**From:** [REDACTED]  
**Sent:** 29 September 2016 14:29  
**To:** Planning  
**Subject:** Comments on Application Reference:6/2016/1778/FULL - 11 Brookmans Avenue Brookmans Park, Hatfield,AL9 7QH

**11 Brookmans Avenue, BrookmansPark, Hatfield, AL9 7QH**

**Application Reference: 6/2016/1778/FULL**

Drawing Title
 PROPOSED SITE PLAN AND
 STREET SCENE

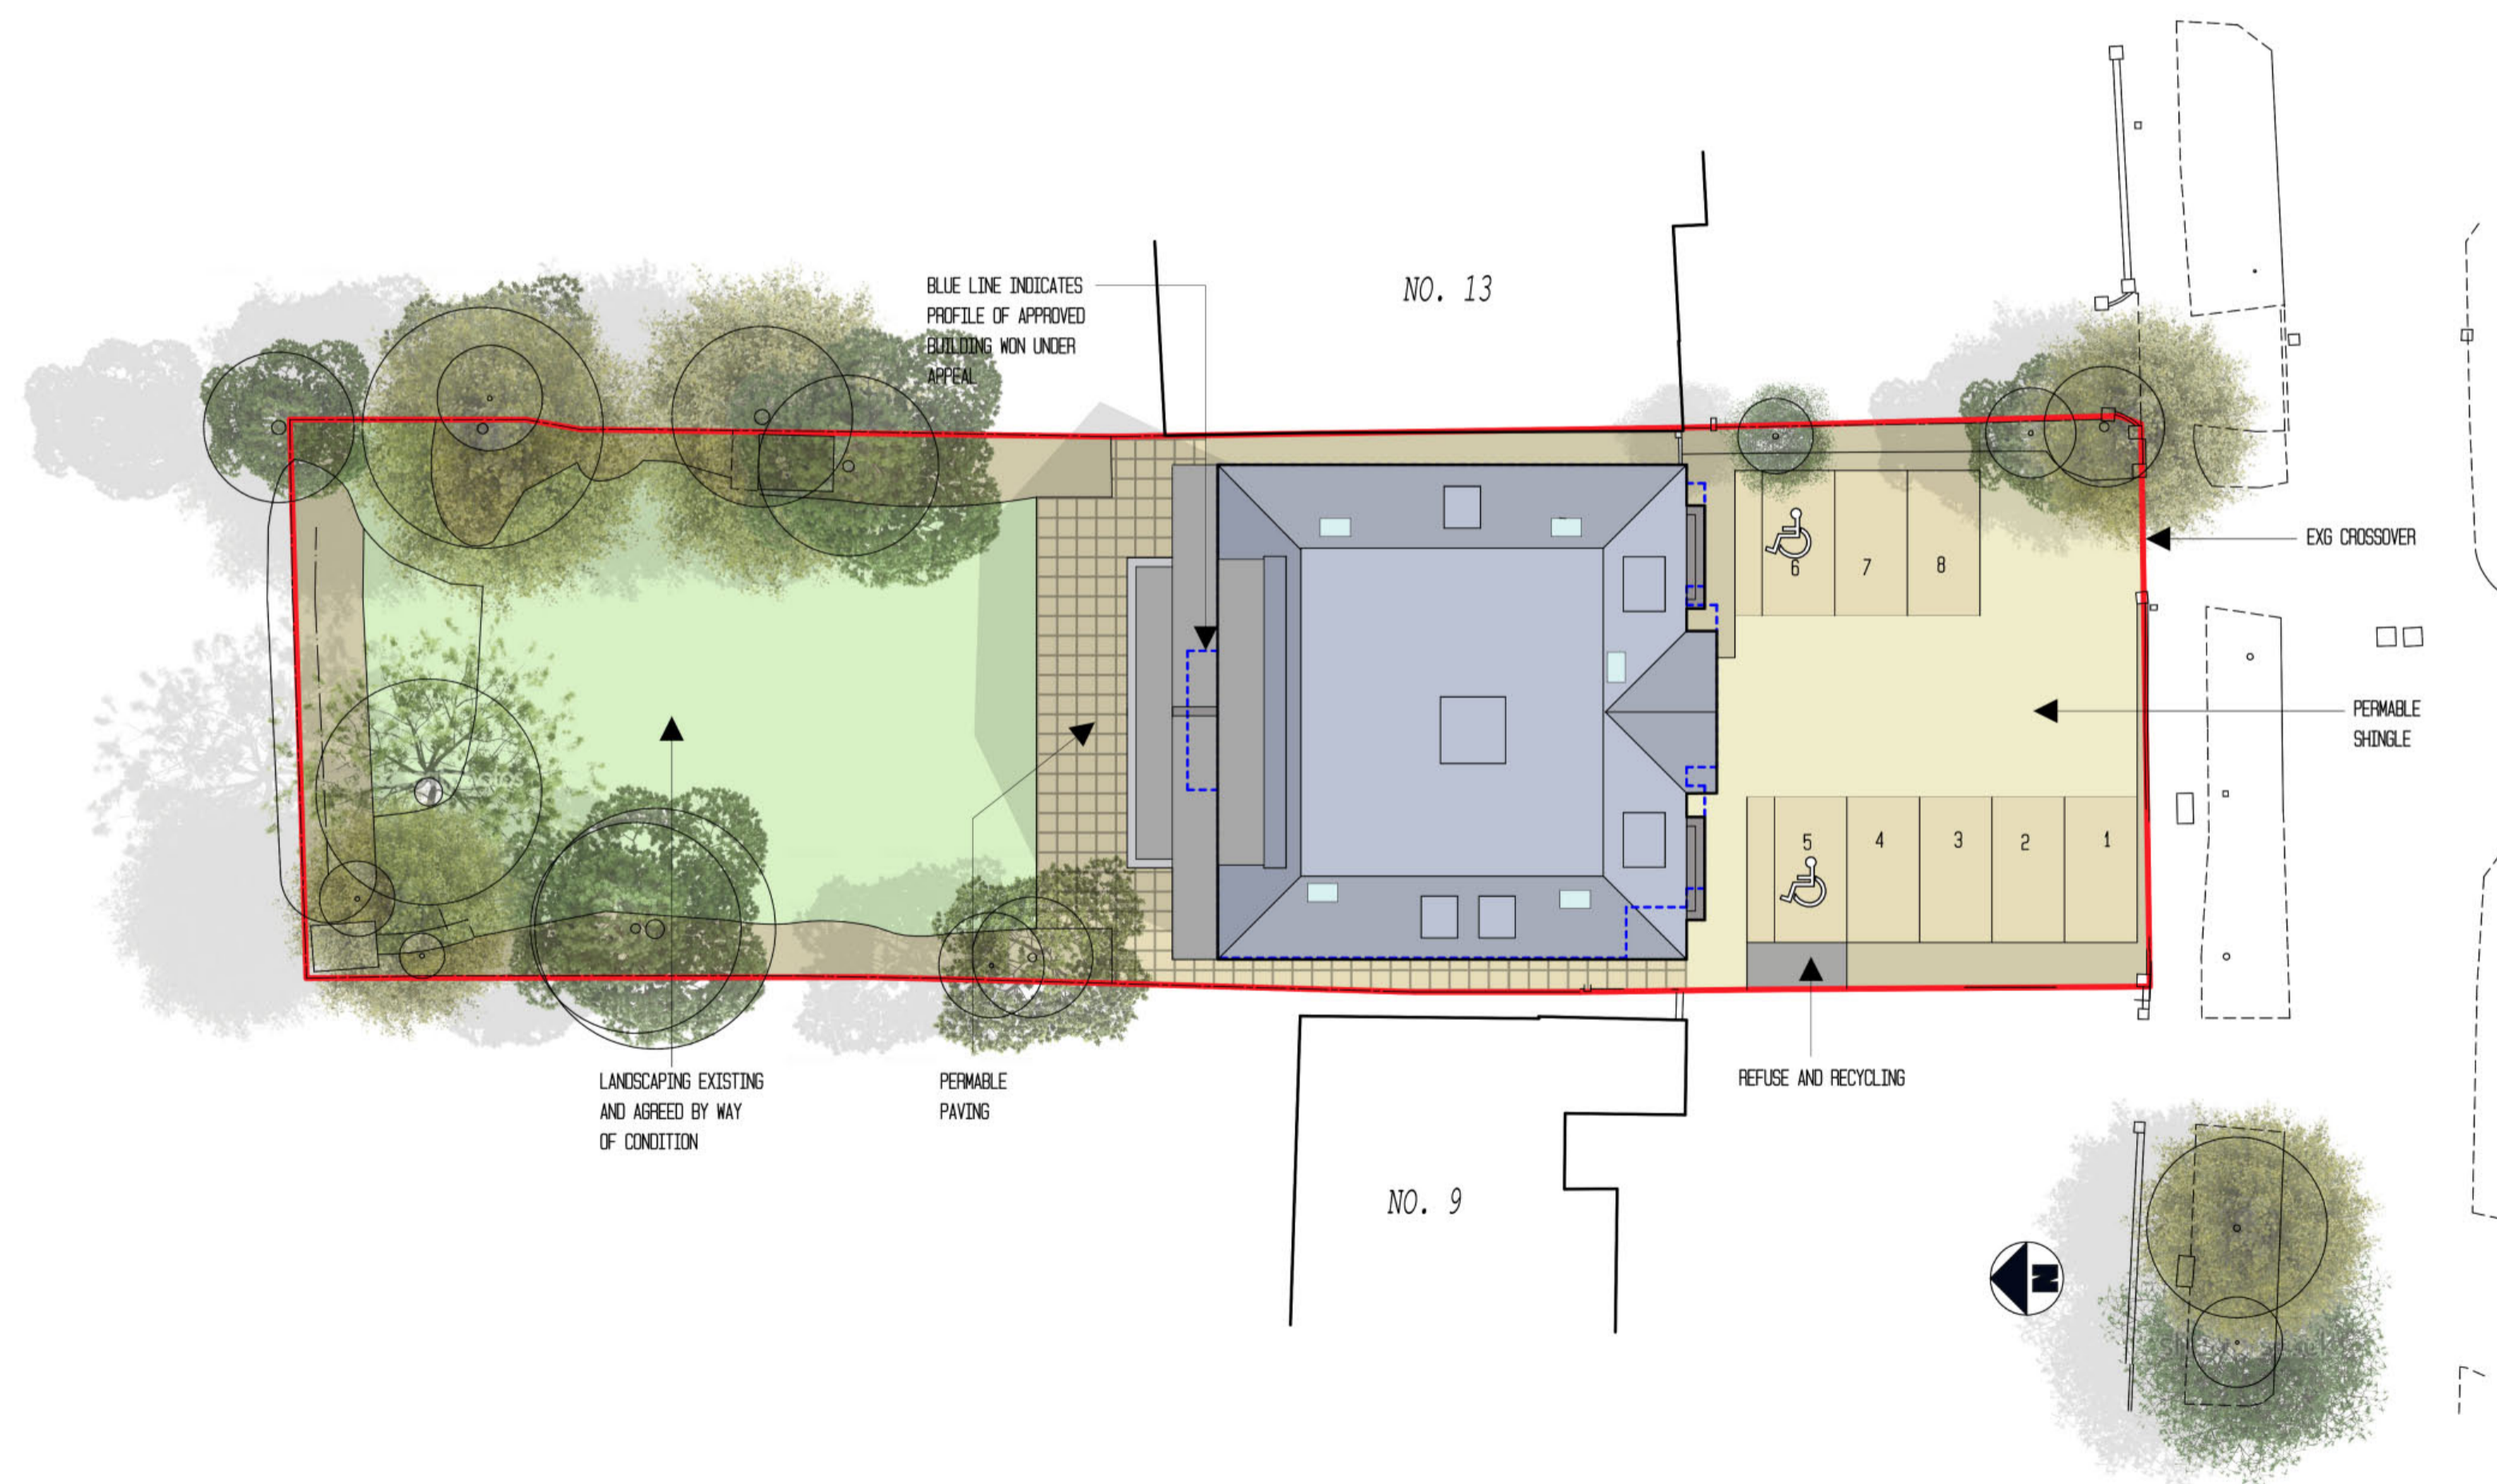
Both my neighbour and I and strongly feel that the development plans should have provision for forecourt parking adequate to accommodate at least **two cars per household** to prevent overspill into street parking in Brookmans Avenue. At present, space for parking in this area of Brookmans Avenue is very scarce and is normally occupied throughout the morning by non-householders, causing a significant traffic bottleneck in view of the narrow avenue passage, despite the recent welcome introduction of late morning parking restrictions.

Also at present, every property in Brookmans Avenue is occupied by only one household with adequate on-plot parking space for at least two cars, thanks to historical planning considerations. The proposed development at 11 Brookmans Avenue will comprise five households for five flats. Will the forecourt parking planned for this development accommodate at least two cars per household i.e. at least 10 cars? If not, traffic congestion in Brookmans Avenue will become a nightmare and set a precedent for other property developers to abandon the principle of on-plot parking for a minimum of two cars per household that has served our community so well up to the present.

As a further thought, since there is forecourt parking planned and the existing building is to be demolished and replaced with a new-build, surely extra room for a “two car per household” principle can be achieved simply by locating the new-build some two metres further to the rear ?
